From: Zac Denton
Sent: 26 April 2019 08:58
To: 'Emma Weaver'
Cc: David Fuller; Laura Gibbons
Subject: RE: Apple Barn Cottage - CM/5/19/HH

The Drainage Engineer has commented as follows:

Project			
Apple Barn Cottage			
A259			
Climping			
Client			
Alex Stephens			
Drawing Title			
Surface Water Drainage			
© This drawing is copyright. It may not be copied or reproduced without written authority.			
Scale	As shown	At original	A3
Drawing Number	2017/SK4	Revision	-

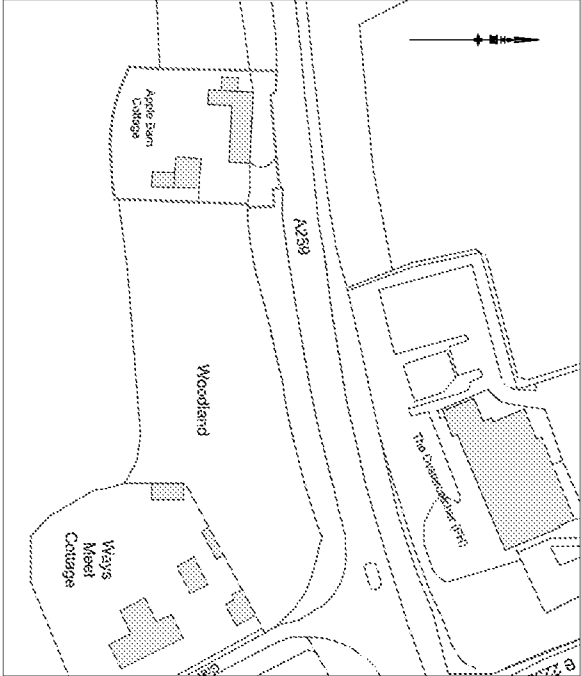
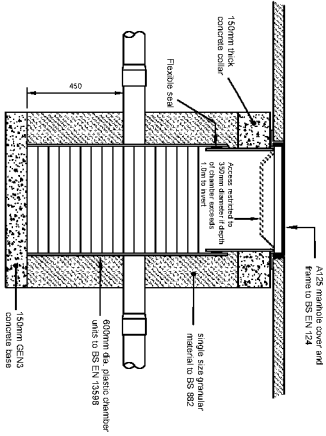
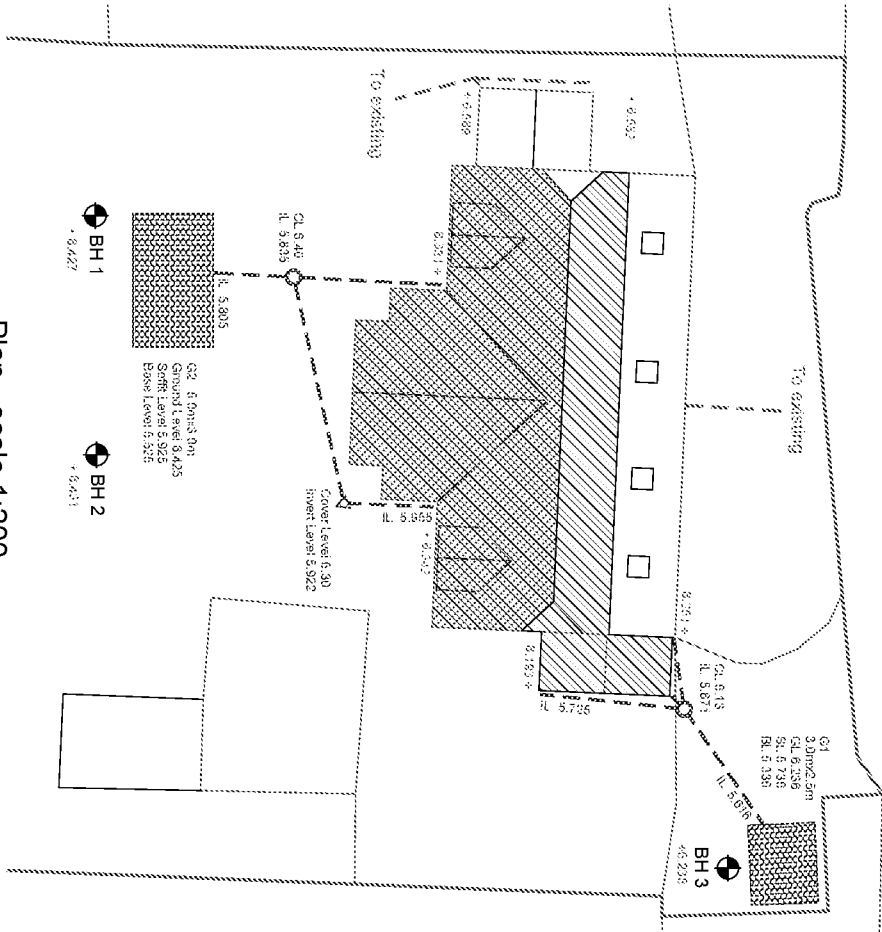
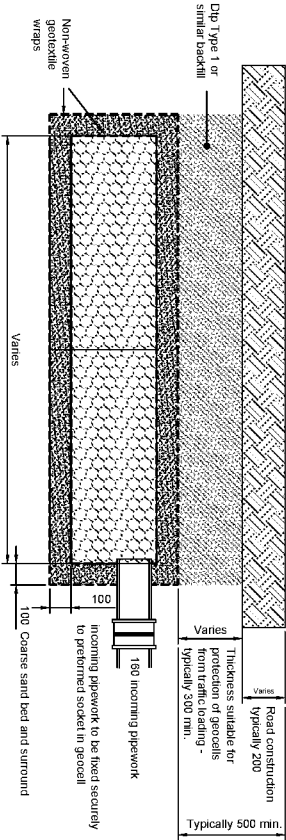
"There is still a lack of calculations. Can these please be supplied?"

Further information has been provided about the depth of infiltration tests and the rates at each testing location. I would like to see the test result from BH3 used in design of G1 soakaway. And the infiltration rate of BH2 at 929mm depth used in the design of G2 soakaway. These results are those that most accurately reflect the location and depth of the proposed soakaways."

Please can we get the surface water drainage calculations supplied to support the proposed design.

Please can the applicant also submit further details of the infiltration testing. I note that the layout states that an average rate has been used in design. Please can the depths of infiltration testing and results be supplied to ensure that the infiltration rate used in design is appropriate.
